03 JUL 2013

Application 3/2013/0357

Land to the north of Huntroyde Home Farm

-  Site boundary
-  Turbine location
-  Indicative proposed access track & turning point
-  Crane pad
-  Sub-station

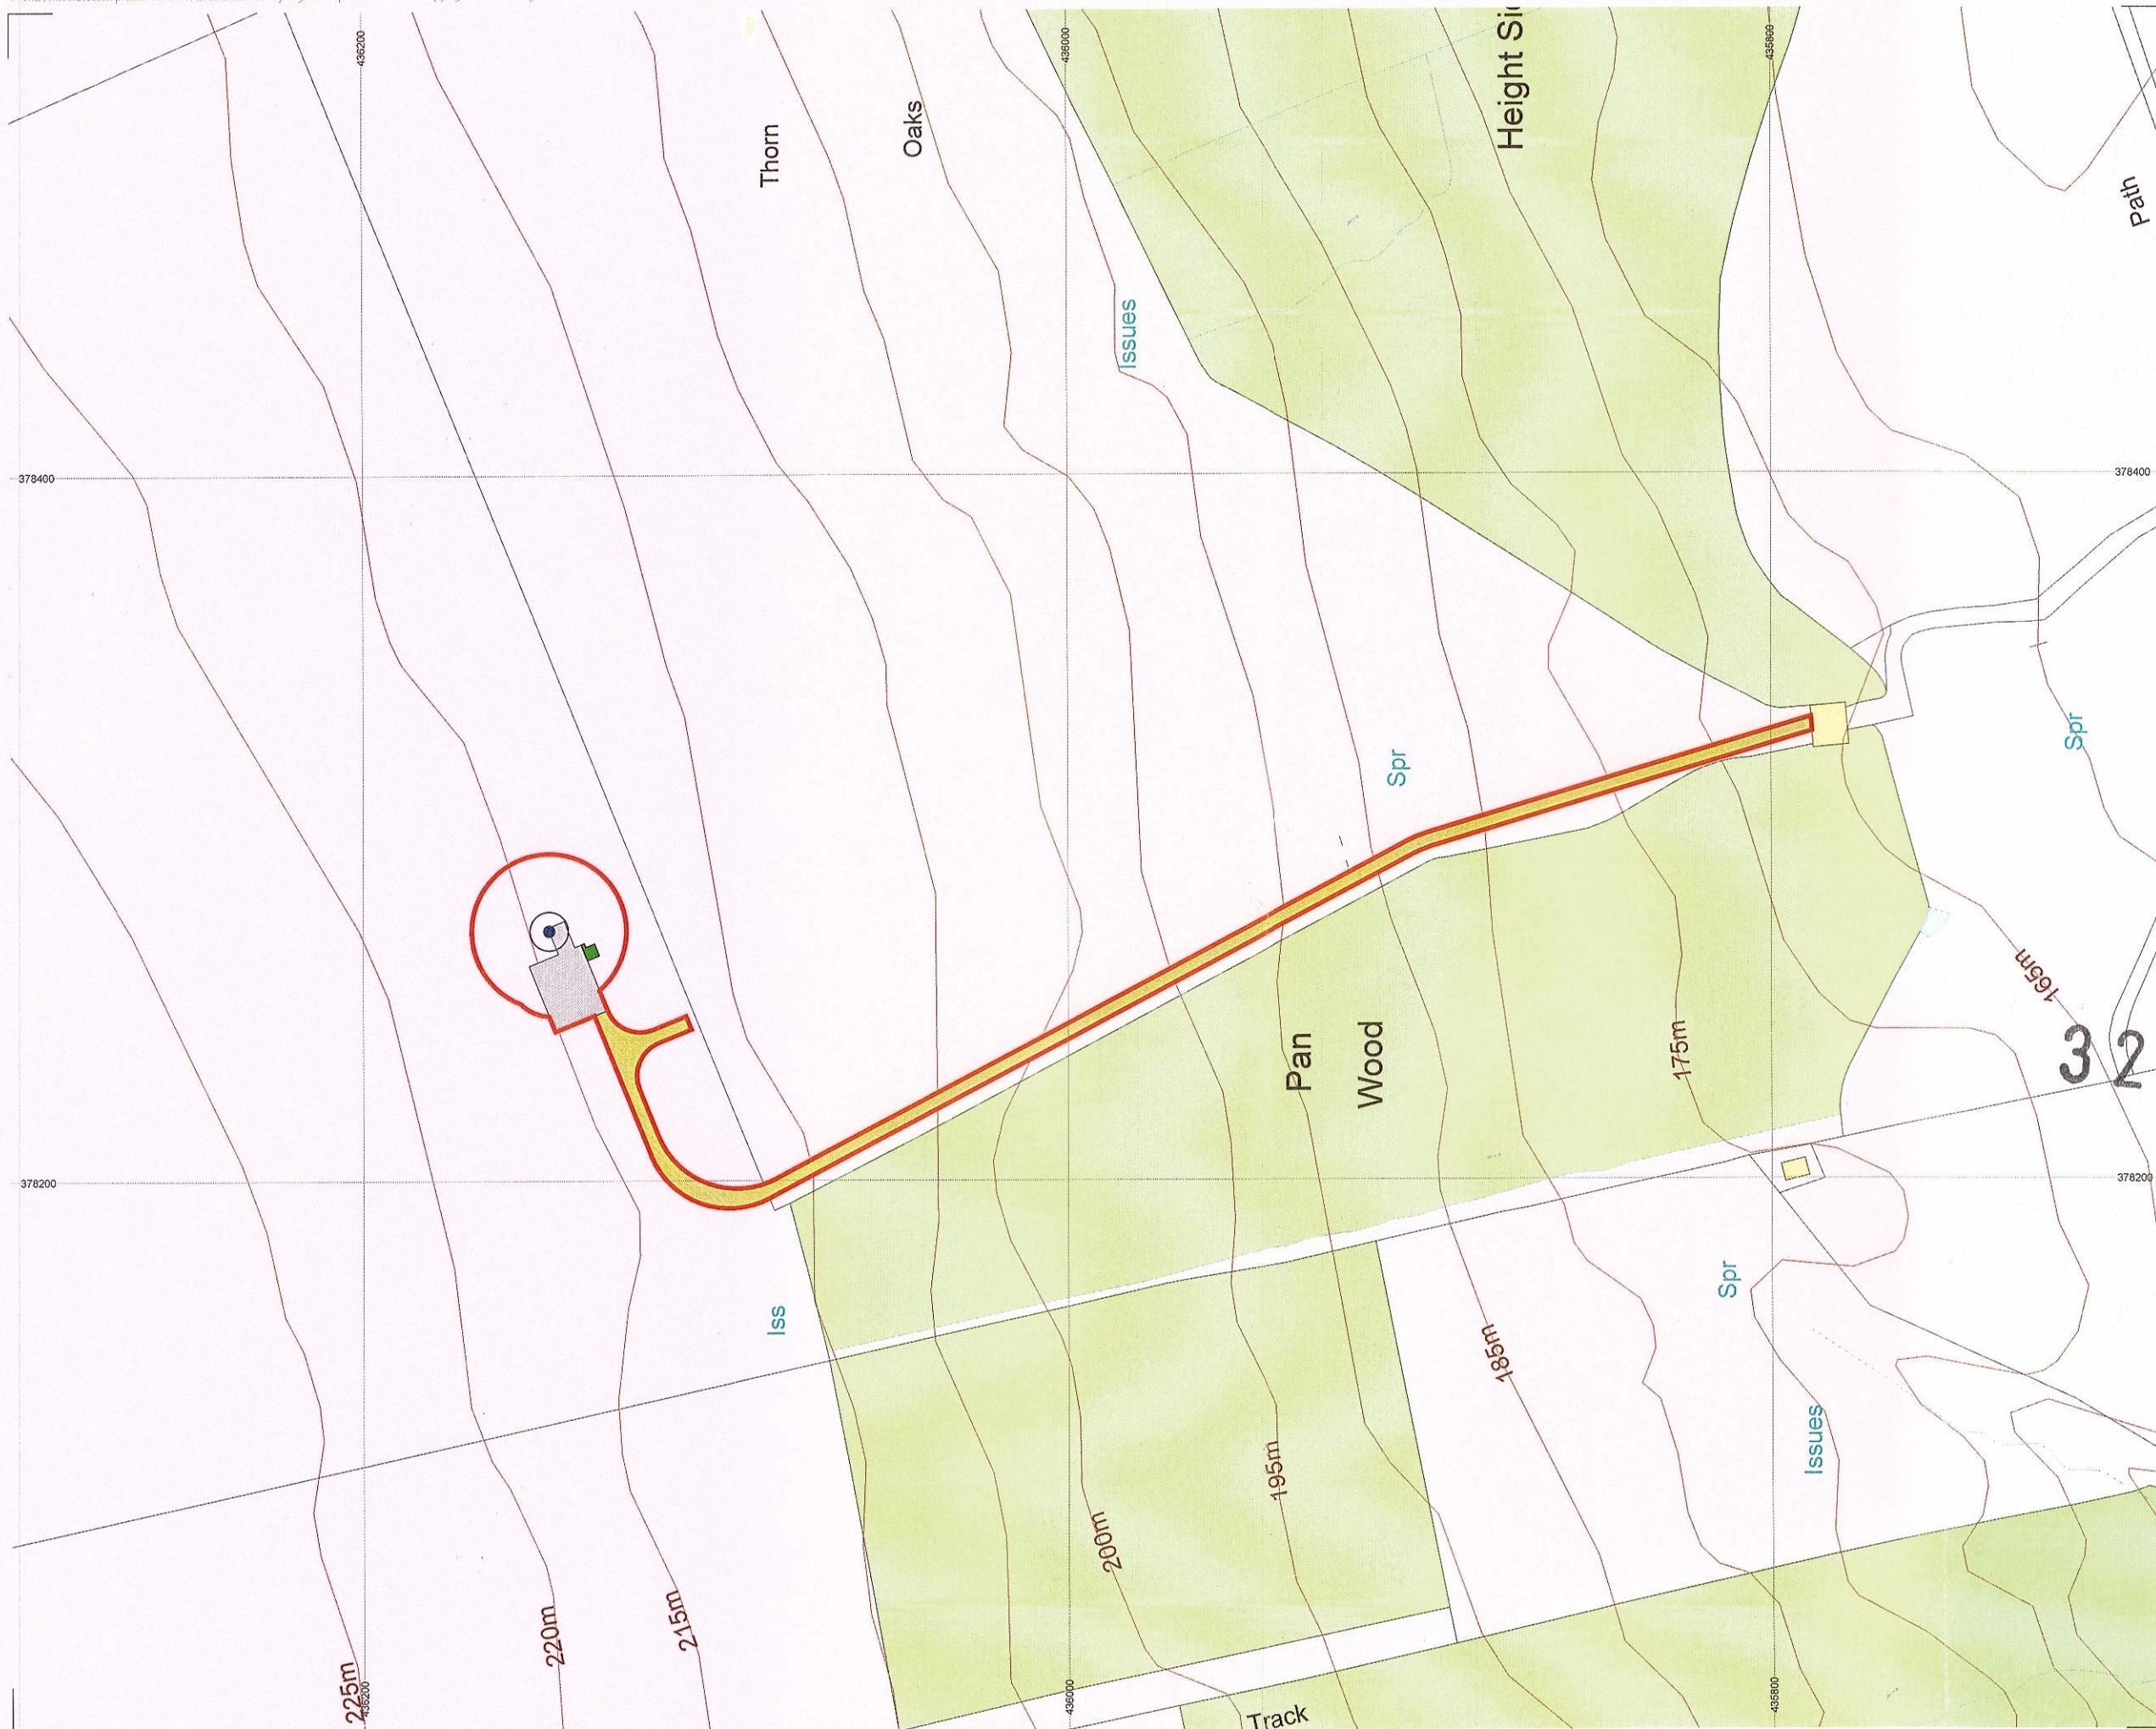
Paragraph 1.3 does not consider the detrimental implications of providing a second and non-static 'eye-catcher' (see '*conflict of visual priority*' in GHS paragraph 5.5 below) in this landscape as well as a new and incongruous roadway.

New or upgraded traffic routes may require considerable subsidiary development in the form of new surfacing (particularly if heavy vehicles are to be accommodated), lighting, signage, speed restriction measures, CCTV etc. All have potential for adverse visual impact and for erosion of the character and appearance of historic landscape. The possible cumulative effect of such subsidiary development should also be taken into account (Watchpoints, 5.1);

The proposal has an unduly harmful impact upon the setting of the Grade II listed Feeding Shed and Huntroyde Hall and the significance of the Huntroyde Demesne designed landscape (non-designated heritage asset) because of the wind turbine and access road's visual intrusion and conspicuousness and its compromise to the Feeding Shed as a designed eye-catcher. This is contrary to Policies ENV19 and G1(a) of the Ribble Valley Districtwide Local, National Planning Policy Framework paragraph 131 (the desirability of sustaining and enhancing the significance of heritage assets and the desirability of new development making a positive contribution to local character and distinctiveness) and paragraph 132 (great weight to the conservation of the significance of a designated heritage asset) and Policies DME4 and DMG1 of the Ribble Valley Core Strategy Regulation 22 Submission Draft.

project title	N155: West Royd
figure title	3.1: Turbine Elevation Plan - Enercon E33; 44m Hub Height
figure reference	N155-GR-PA-003_1B
scale	1:250 @ A3
date	August 2012

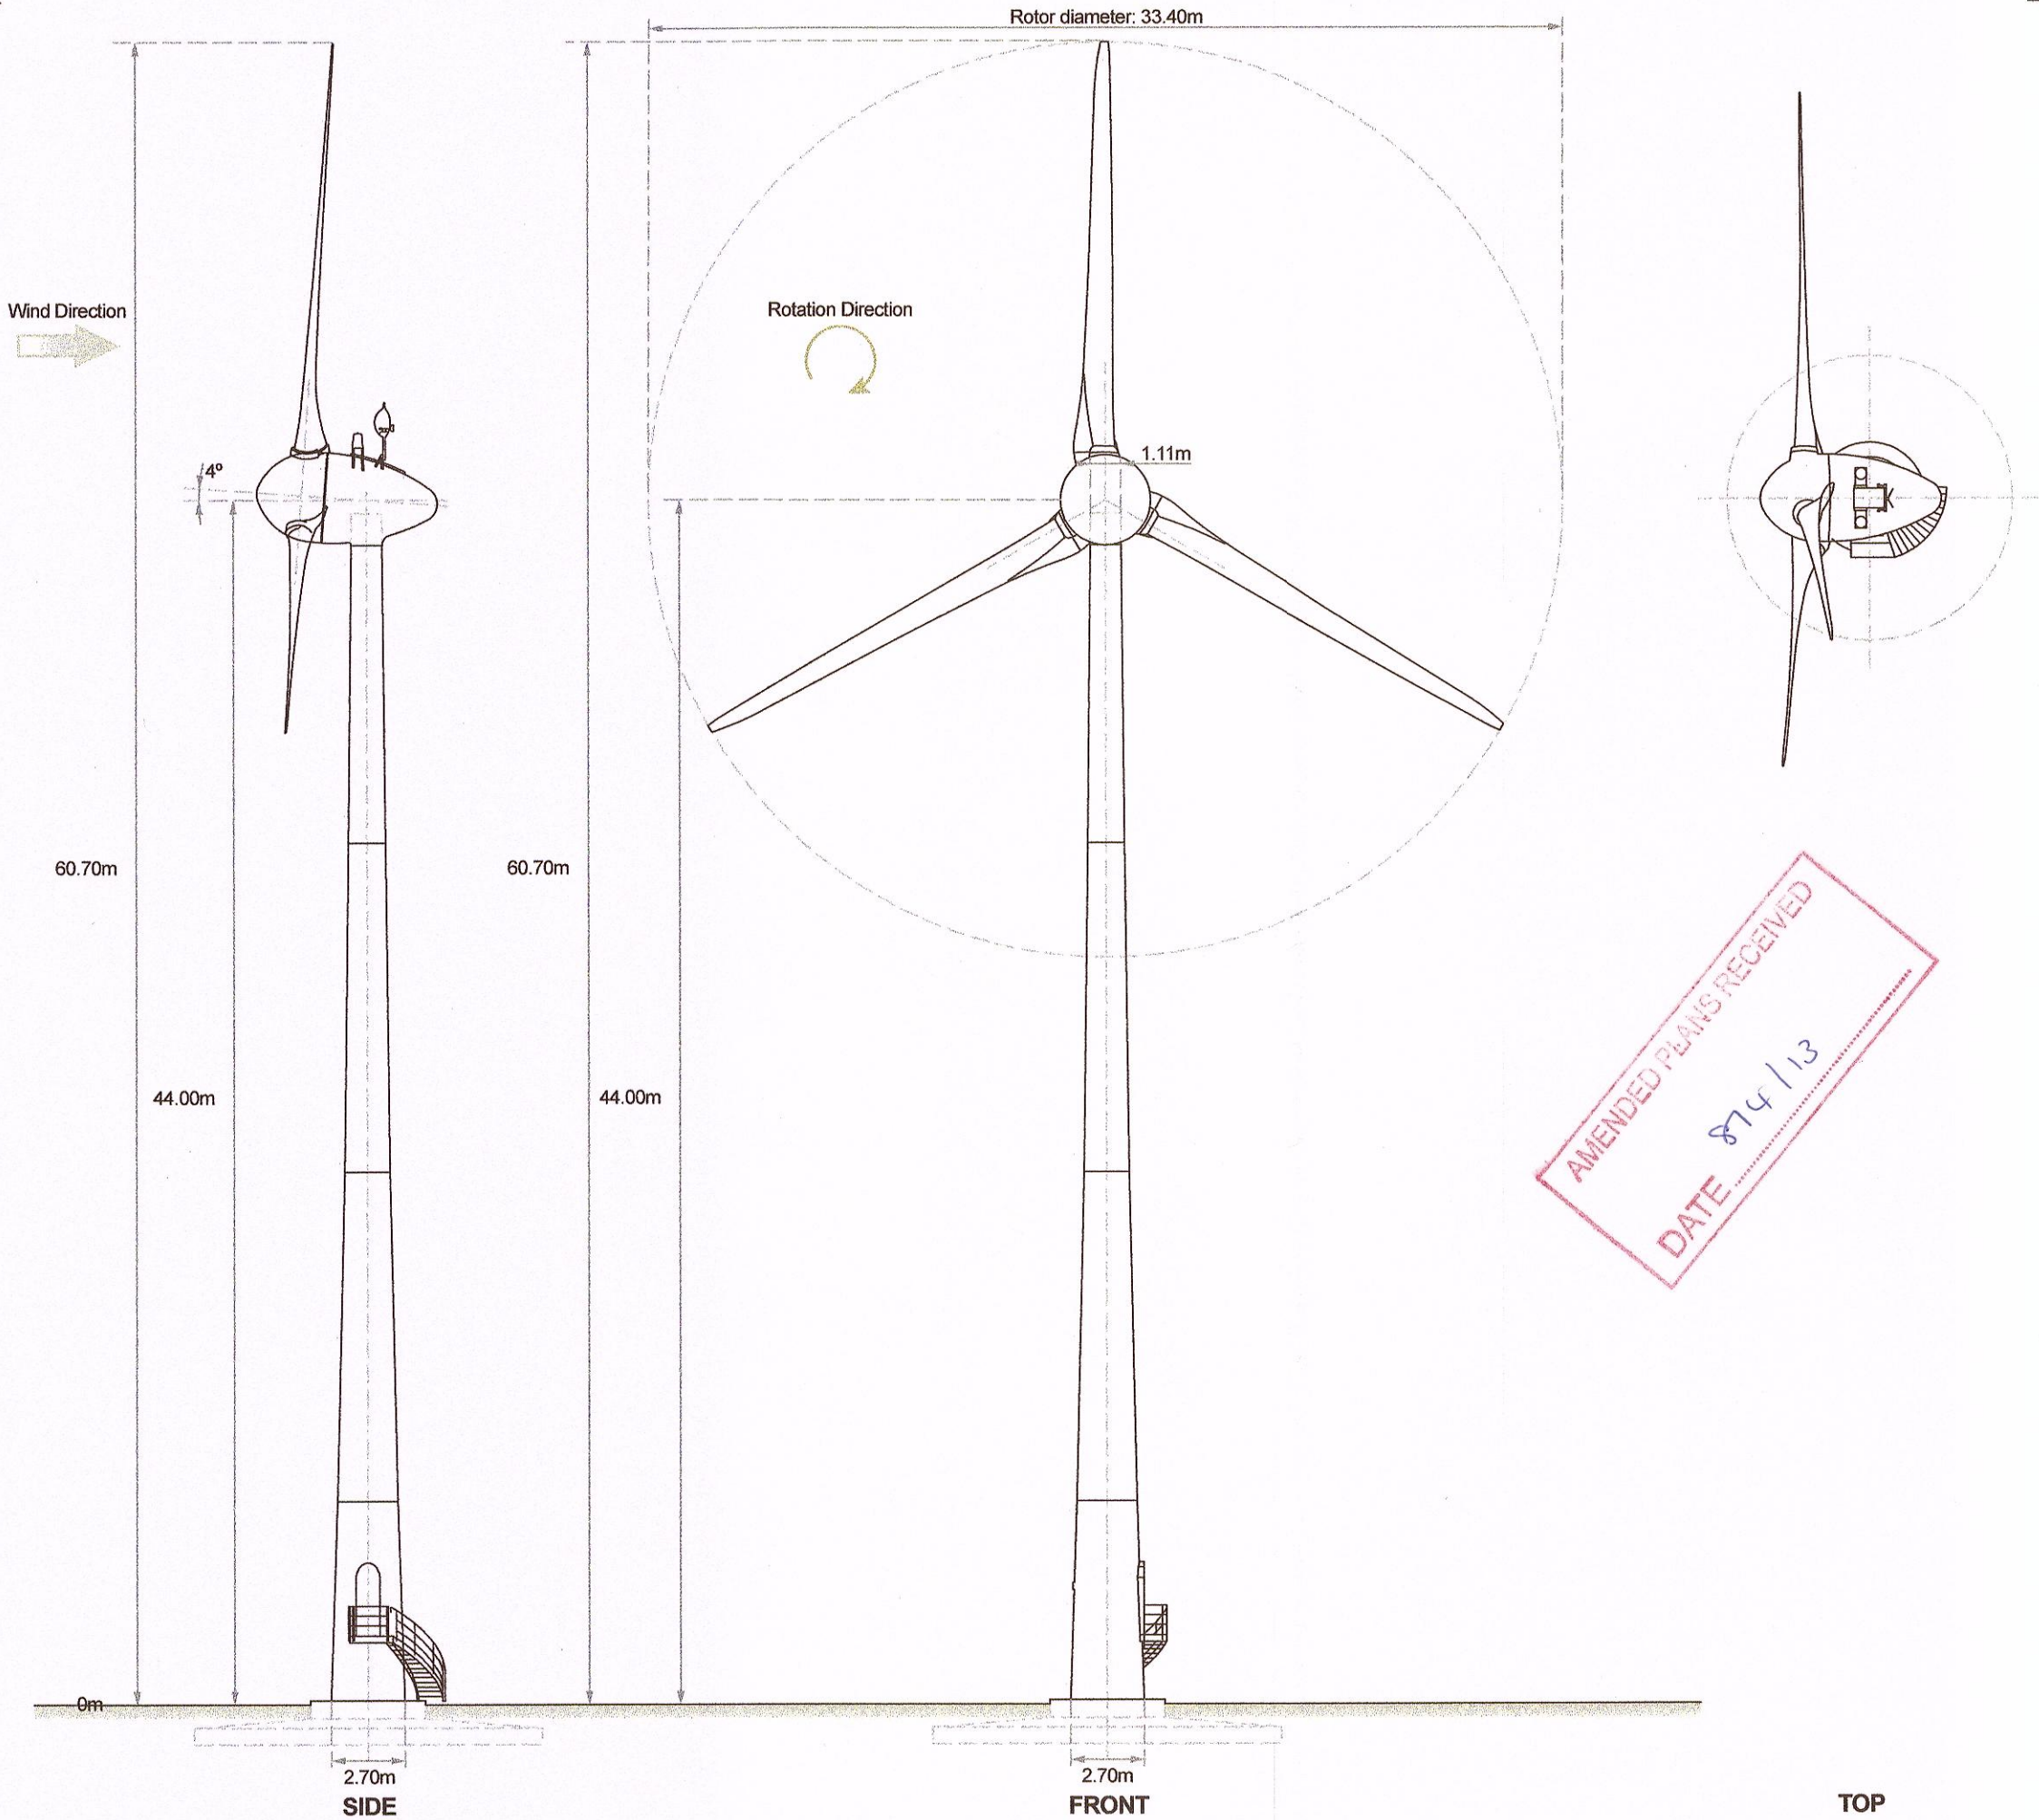
Imposition of an alien structure, or parts of it, on the periphery of a focussed view (e.g. along an avenue or between ornamental buildings or block planting) can immediately draw the eye away from that designed view (conflict of visual priority).
